DEVELOPMENT HEARING OFFICER - HYDROLOGY SECTION
Anthony Montoya, Jr., PE, Senior Engineer | 505-924-3314 amontoya@cabq.gov

DRB Project Number: 2020-003484 Hearing Date: 01-08-2024
Project: Volcano Cliffs, Lots 2 & 3, Blk 12, Unit 3 Agenda Item No: 1

PR-2020-003484

SD-2023-00048 – PRELIMINARY PLAT

PRELIMINARY PLAT FOR
MOJAVE RIDGE SUBDIVISION
 (A REPLAT OF LOTS 2 & 3, BLOCK 12,
 UNIT 3, VOLCANO CLIFFS SUBDIVISION)
 WITHIN
 SECTION 27,
 TOWNSHIP 11 NORTH, RANGE 2 EAST, N.M.P.M.
 CITY OF ALBUQUERQUE
 BERNALILLO COUNTY, NEW MEXICO
 DECEMBER, 2022

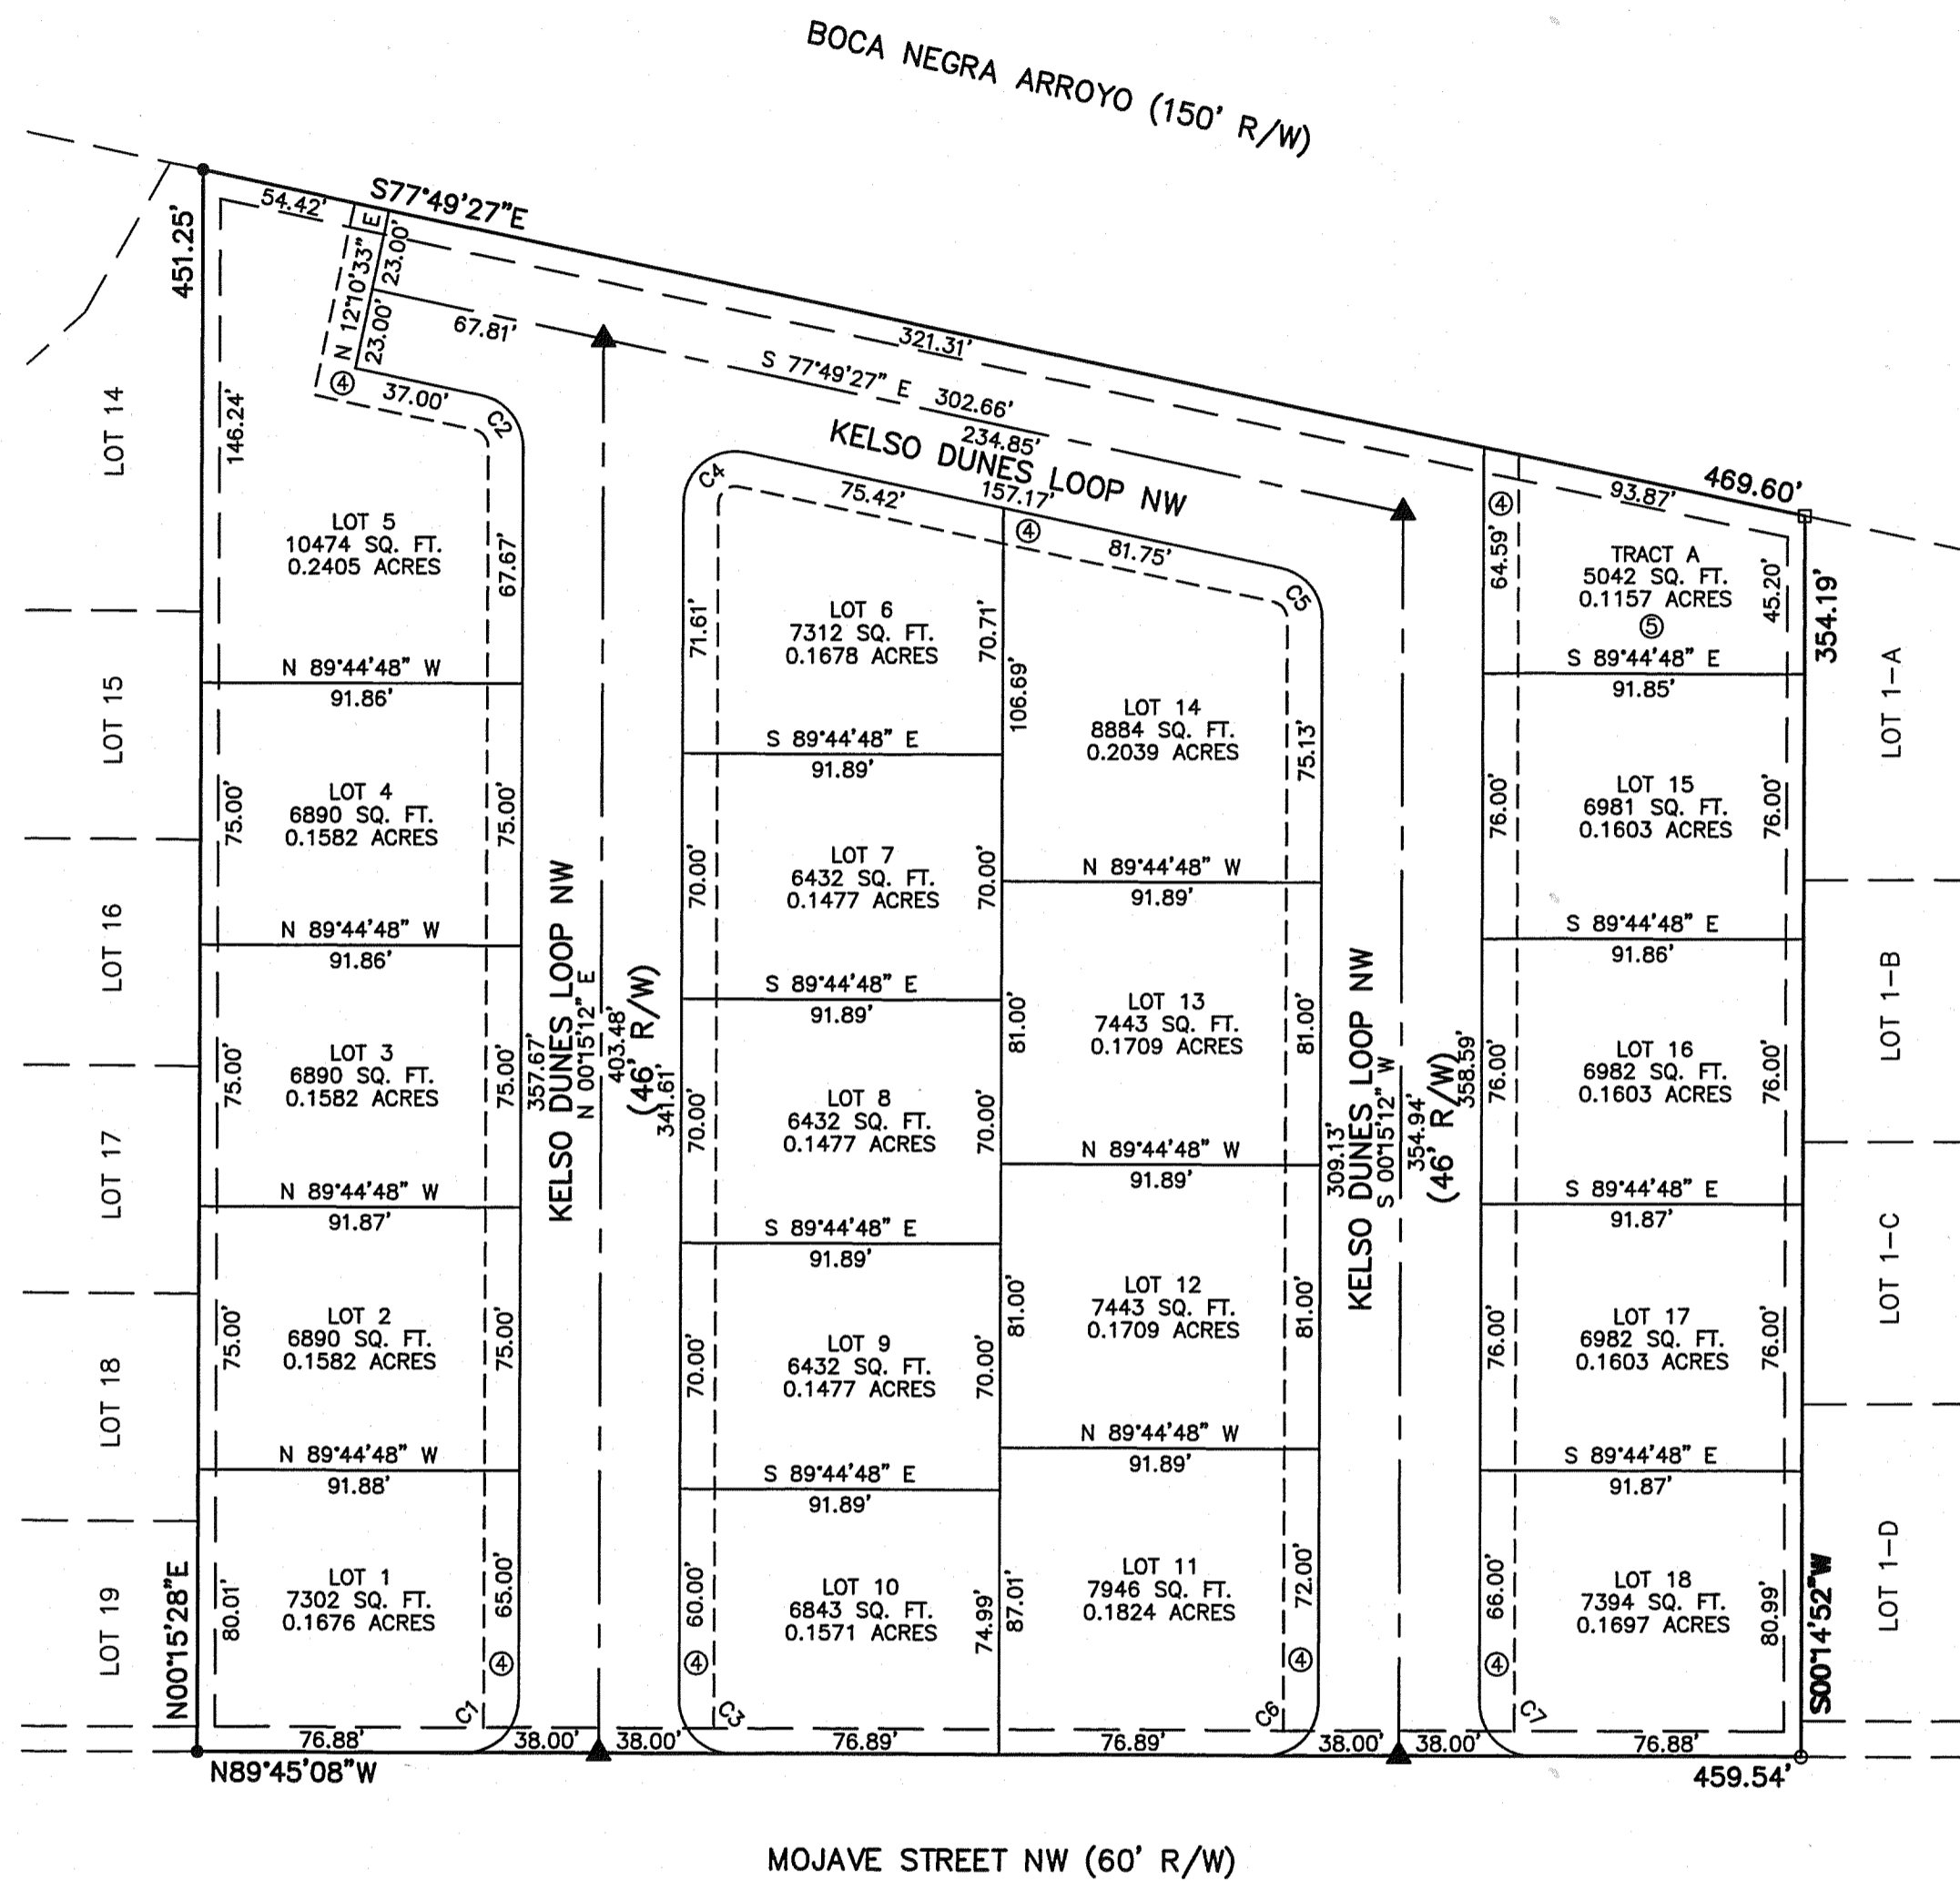
Please note on the plat that the Boca Negra Arroyo parcel is zoned NR-PO-B Major Public Open Space/Petroglyph National Monument. This helps staff identify standards that will be required when the site is developed.

Please note on the plat the 45' landscape buffer required on Tract A due to adjacency to MPOS – No development is allowed and plant species and location must be approved by the Open Space Superintendent.

Has the applicant spoken with NPS regarding sewer connection?

CITY OF ALBUQUERQUE
 PUBLIC WORKS DEPARTMENT
 ENGINEERING DEVELOPMENT GROUP
MOJAVE SUBDIVISION
 GRADING AND DRAINAGE
 GRADING PLAN

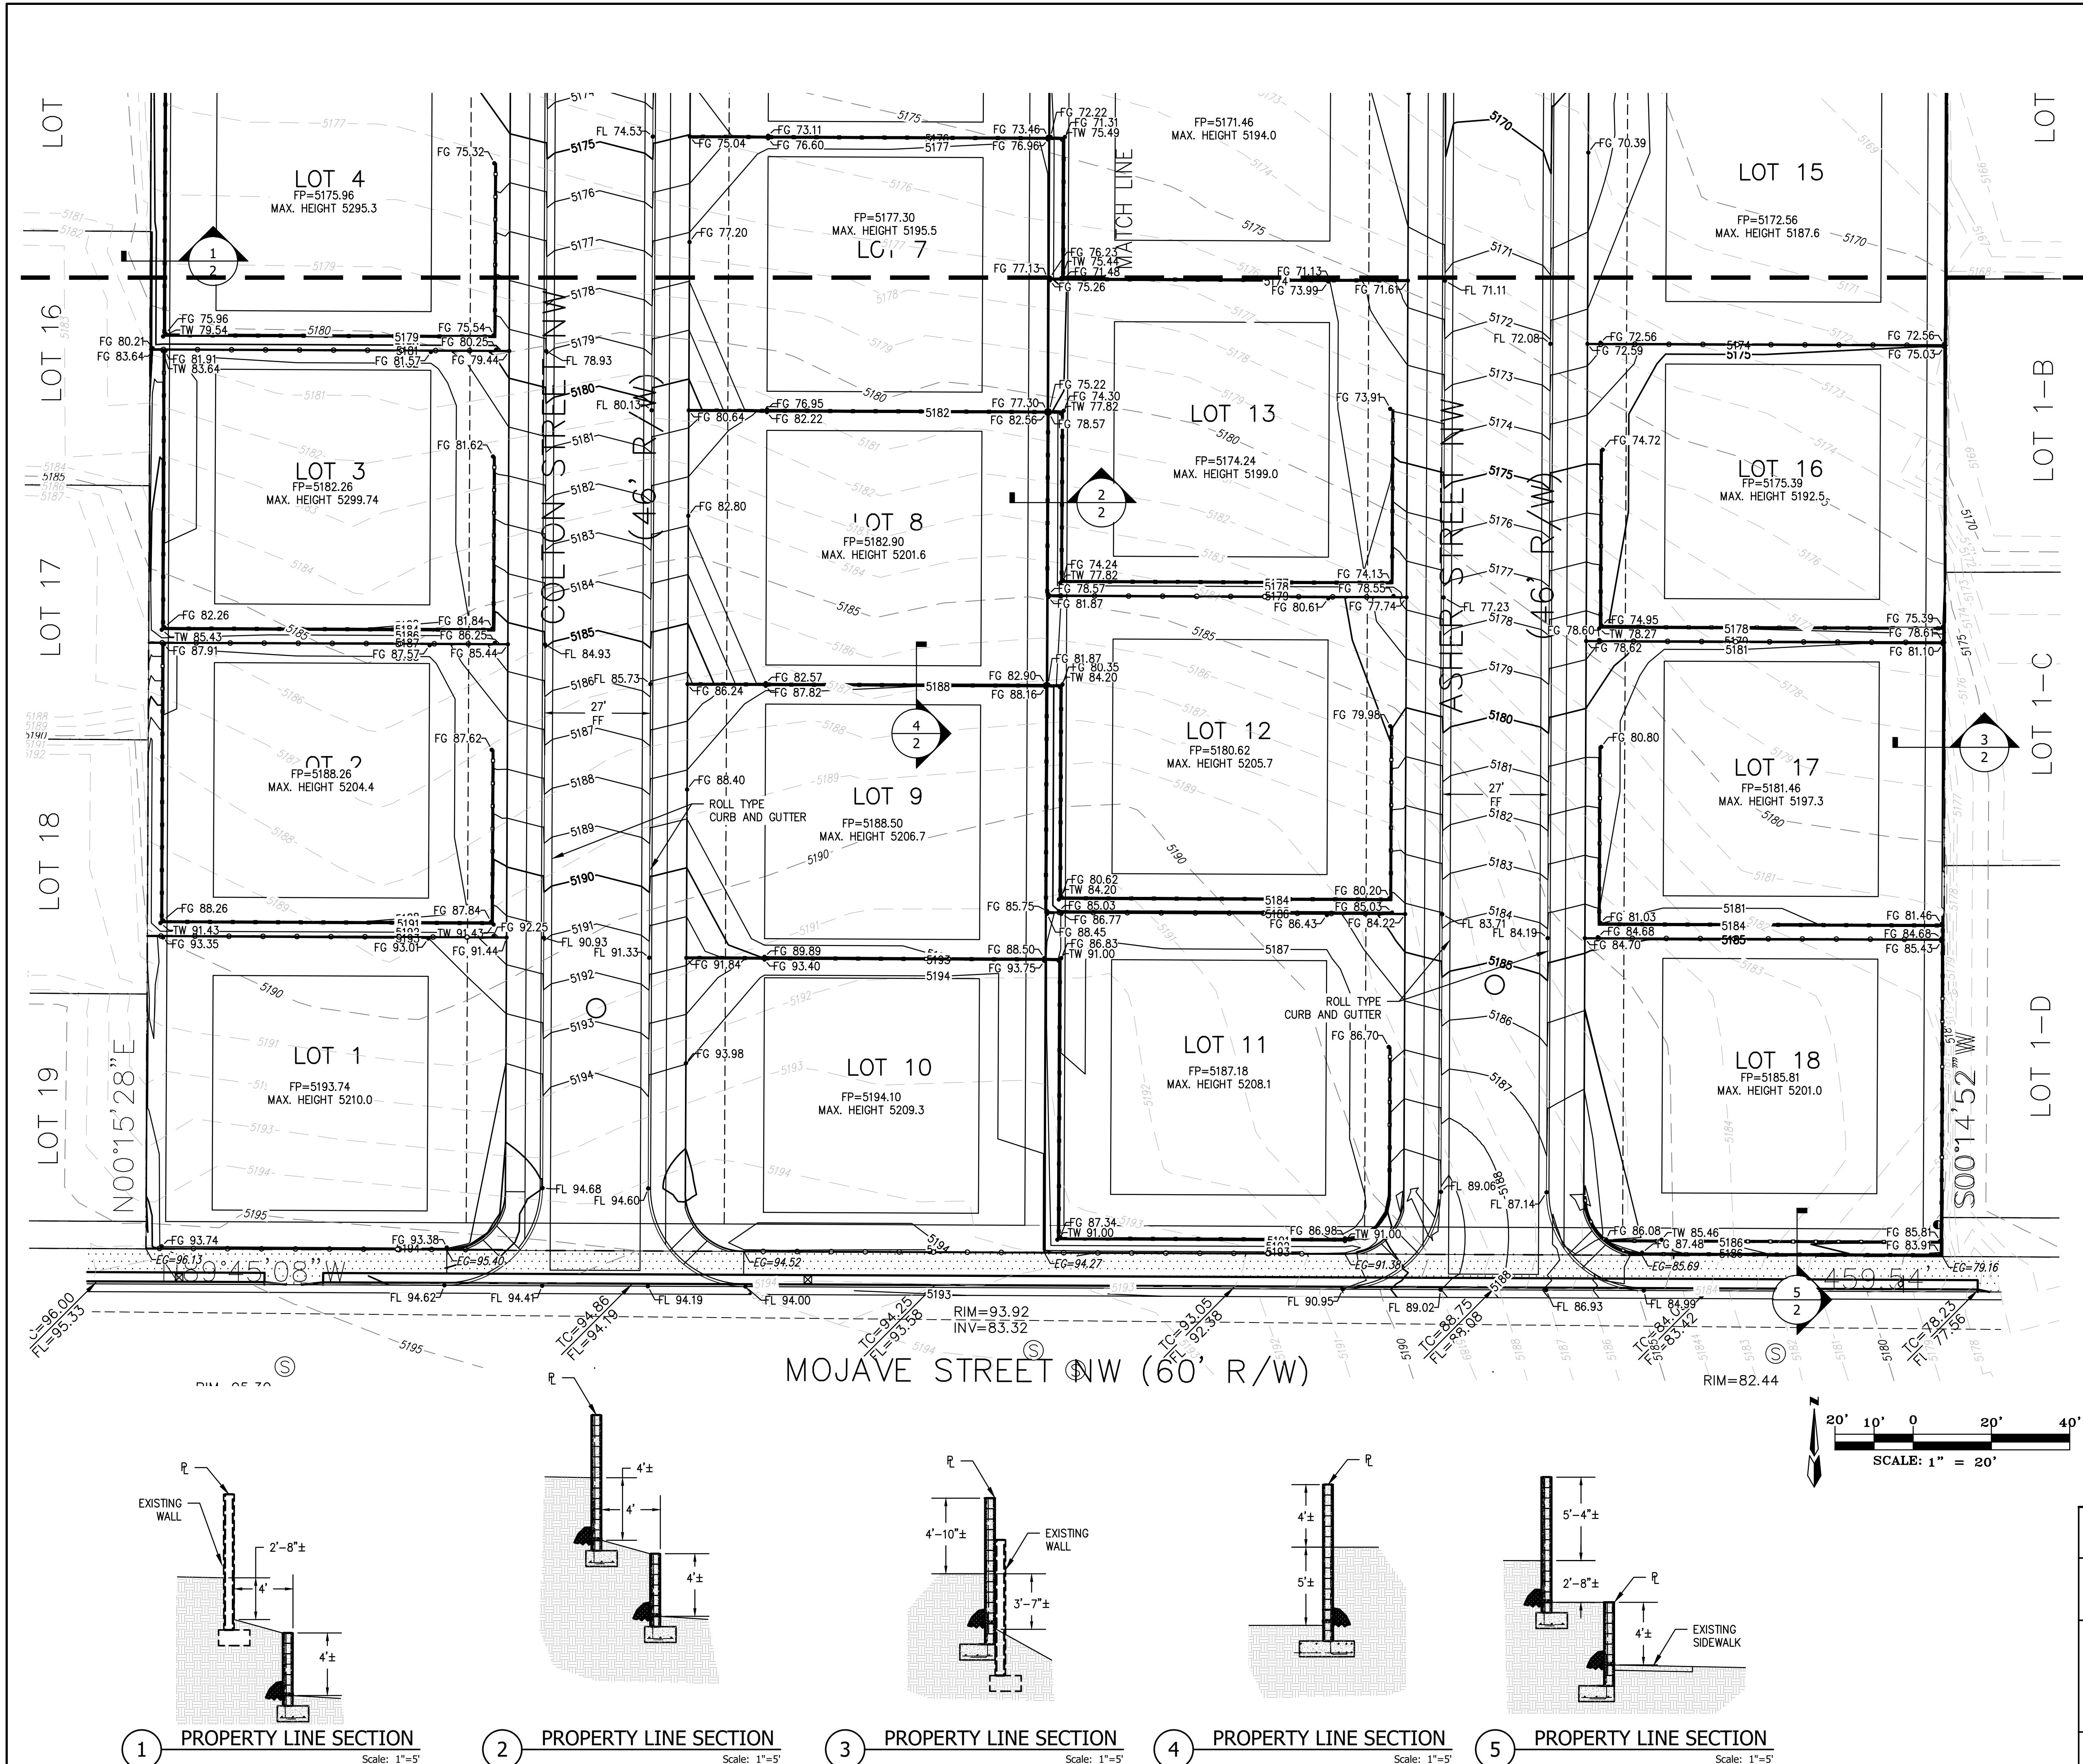
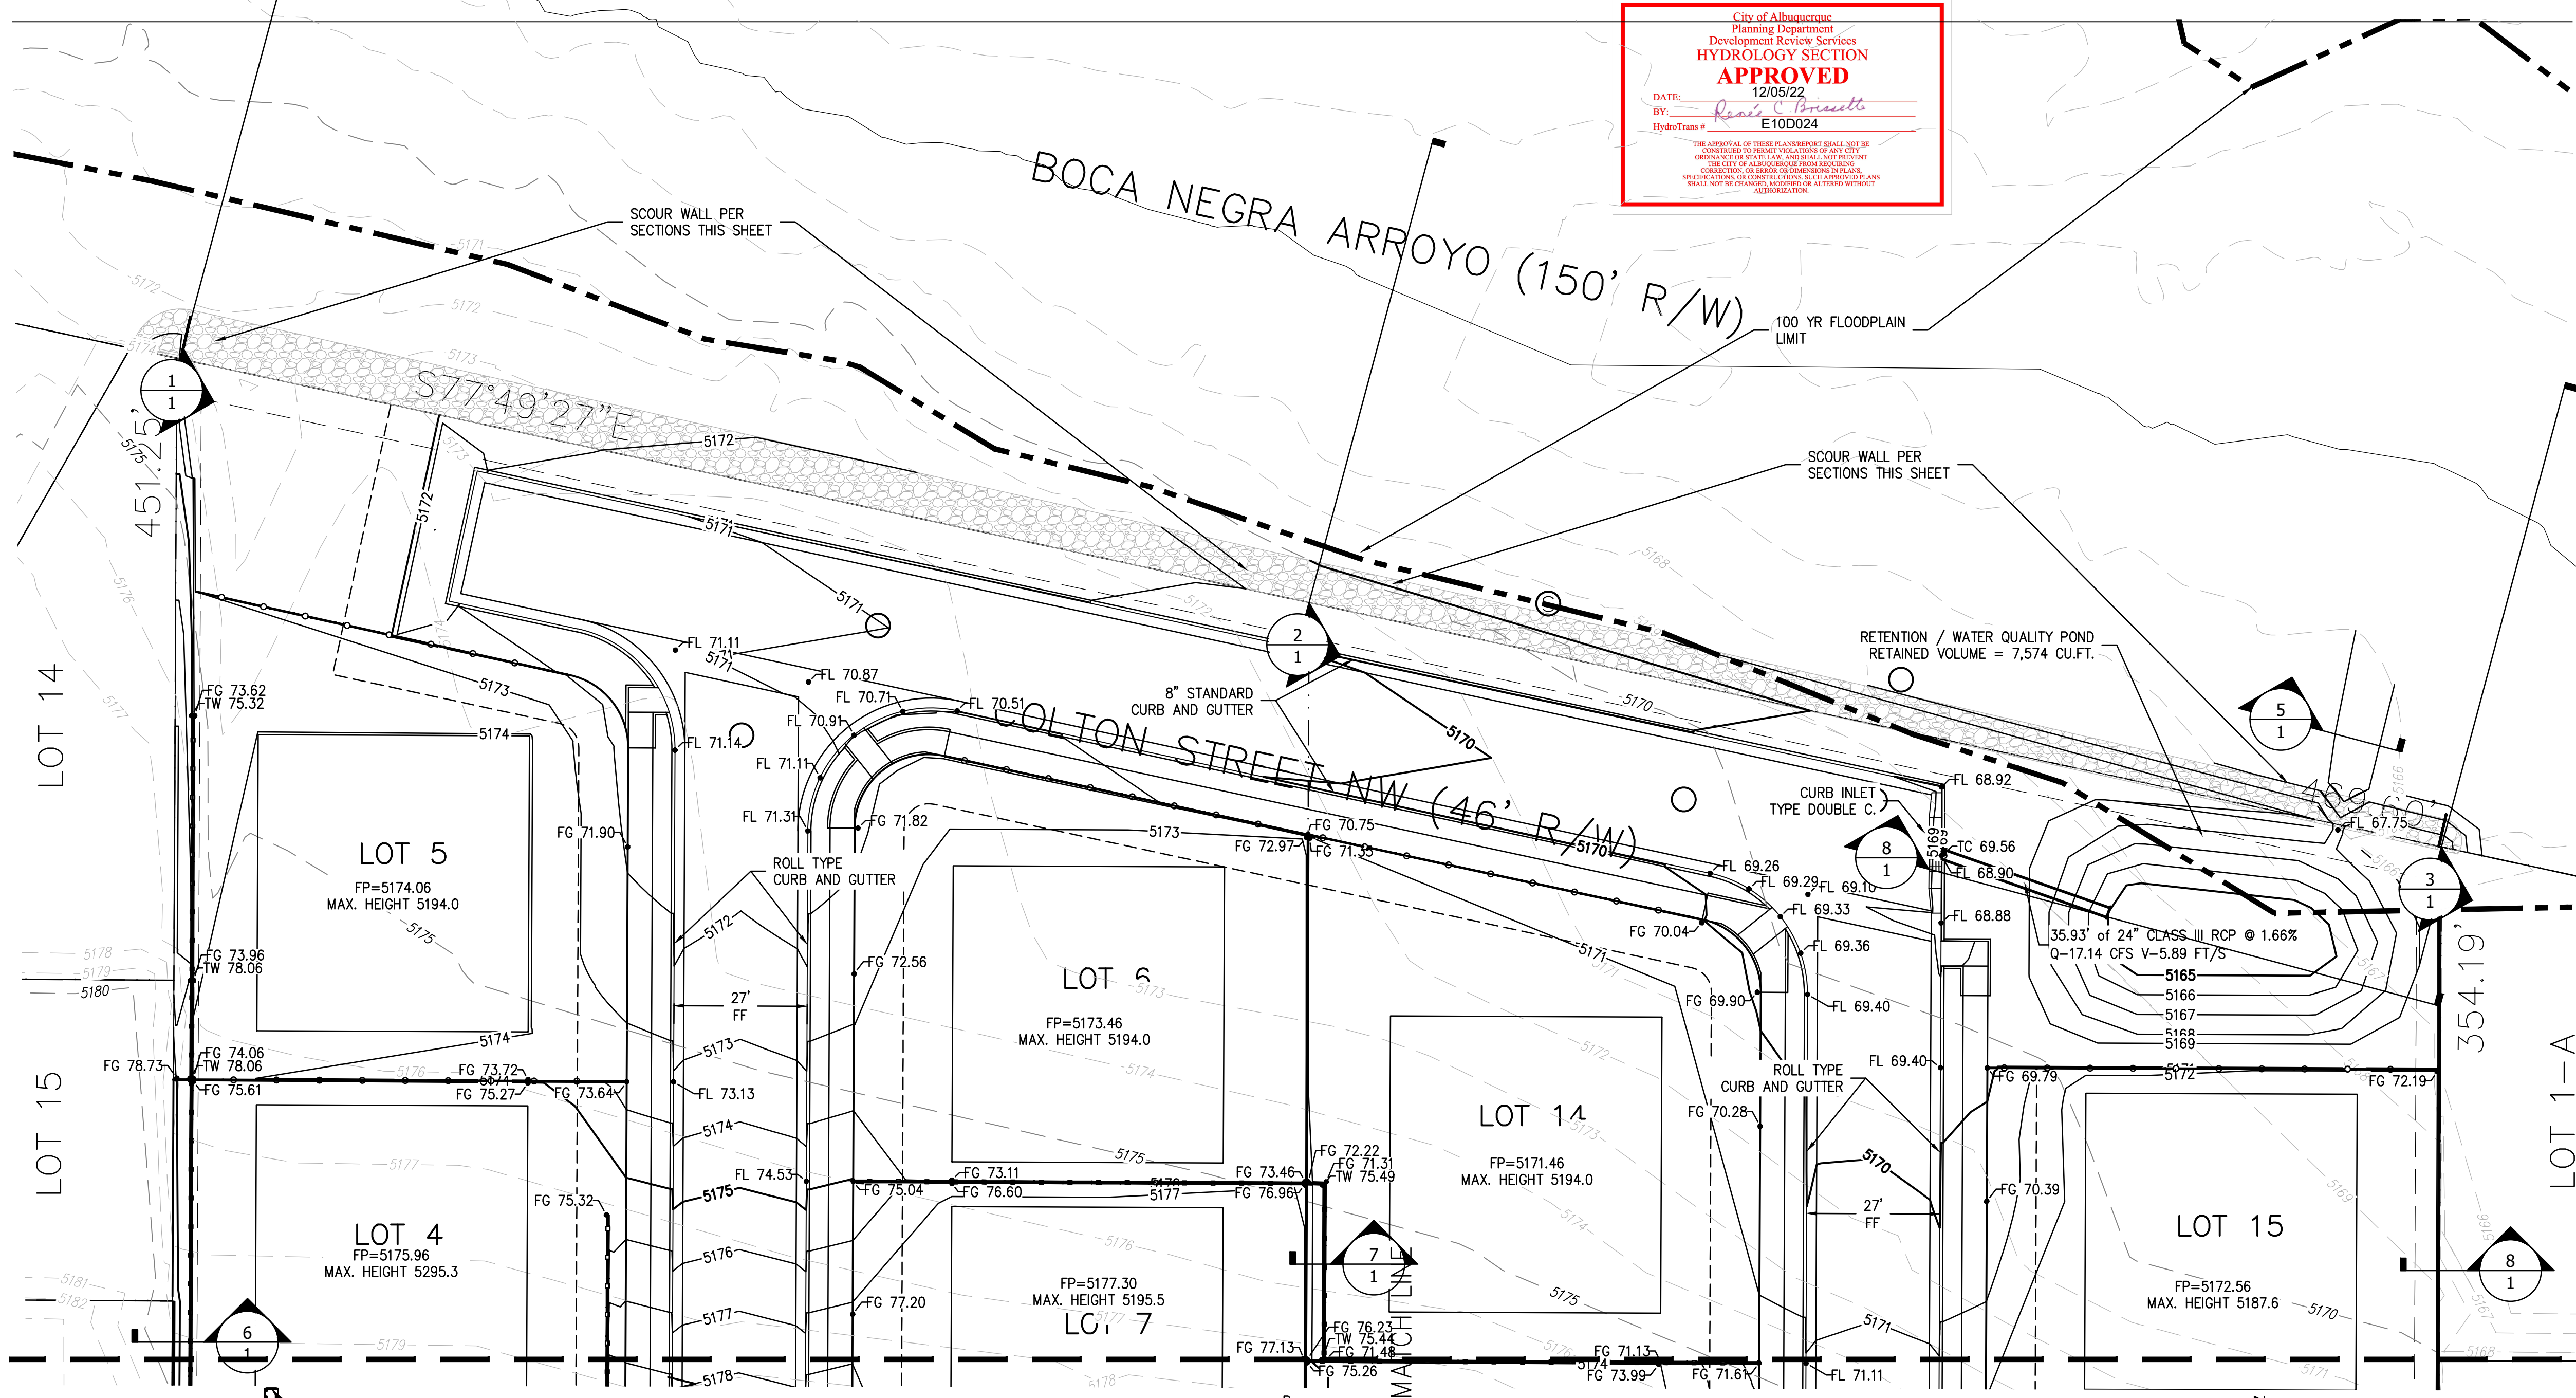
- Due to the location of the proposed pond and the existing Zone AE, Floodway, Hydrology requires an updated Grading and Drainage Plan prior to approval of Preliminary Plat or Site Plan for Building Permit.
